Please ask for: Mrs D Johnson
Email: daun.johnson@arun.gov.uk
Telephone: 01903 737762
Our Ref: WA/21/20/L
Your Ref:
Date: 24th March 2020

Listed Building Consent for Alterations, Extension or Demolition of a Listed Building

Development: Listed building consent for the demolition of redundant building ancillary to main house.
Location: Days Days Lane Aldingbourne BN18 0TA

Location Plan 1:1250

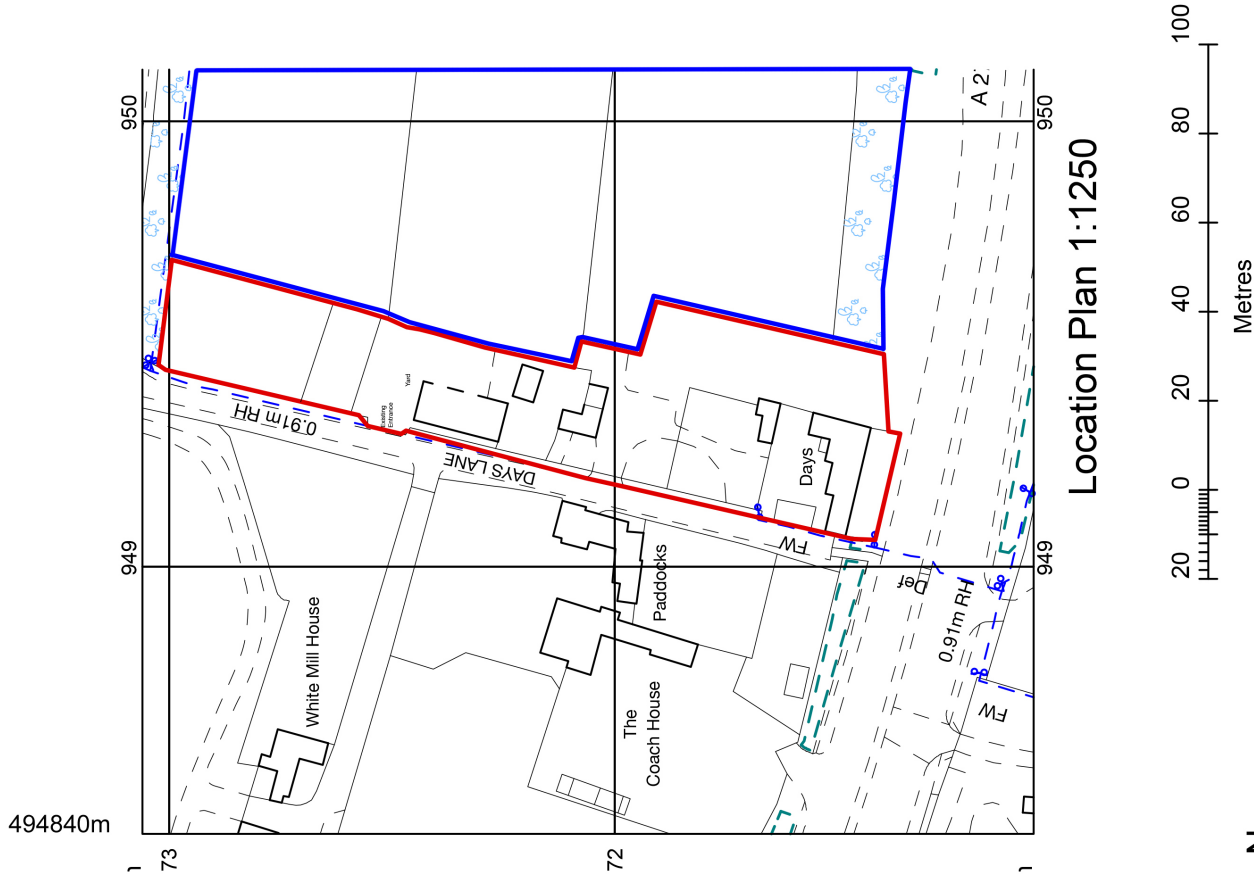
On the location plan, please provide a full blue edge.
